CITY OF ALBUQUERQUE

May 21, 2013

**Re: Albuquerque Sporting Center, Tract A-1, Albuquerque West Unit 2
Grading and Drainage Plan
Engineer's Stamp dated 5-8-13 (C13/D029)**

ENGINEER'S SEAL	PRIMROSE SCHOOL OF NW ALBUQUERQUE	DRAWN BY pm
	GRADING PLAN	DATE 3-20-18
		DRAWING
		SHEET # 4
		JOB # 2017092

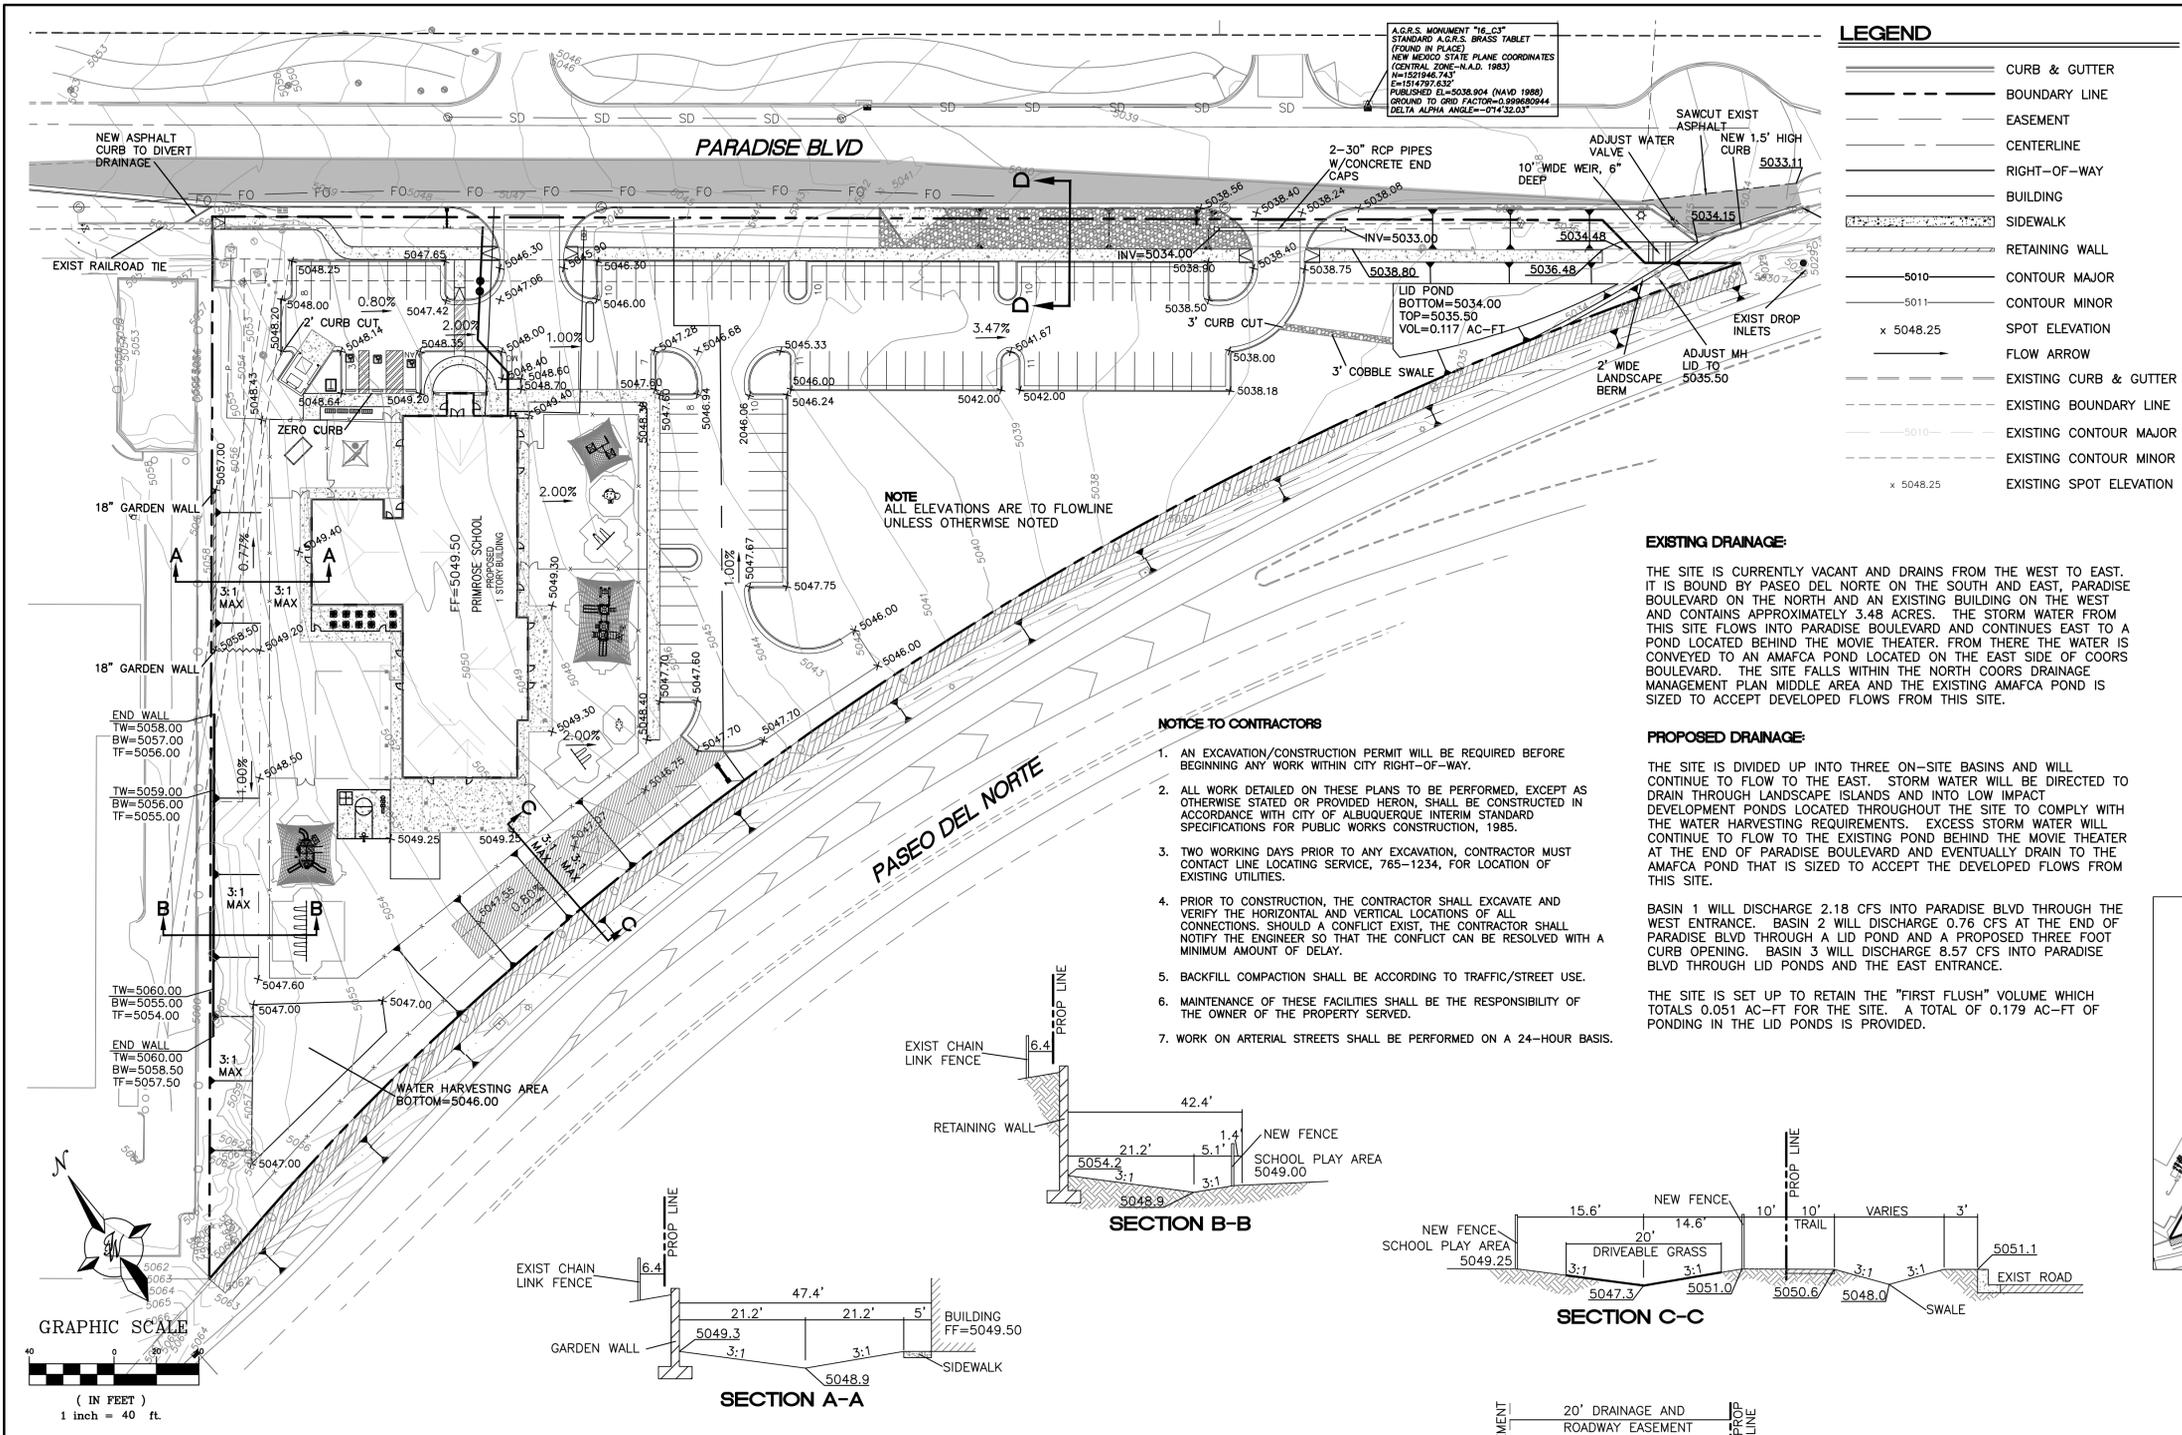
- The temporary pond must be sized to hold the 10-day volume and calculations must be provided to verify this volume.
- Please submit an updated drainage report that reflects the current conditions of the project.
- Please provide a copy of the basin map used in Smith Engineering drainage study.
- Based on the report it is determined that the 77.76 cfs is greater than the 100-yr/6-hour storm based on the land treatments Smith Engineering had used in their analysis. Please provide supporting calculations.
- Approval from NMDOT will be required for the work along Paseo Del Norte.
- Add a permanent benchmark designation and legal description to the grading plan.
- Sheet No. 4-A should be titled "Phase 1 Grading and Drainage Plan".
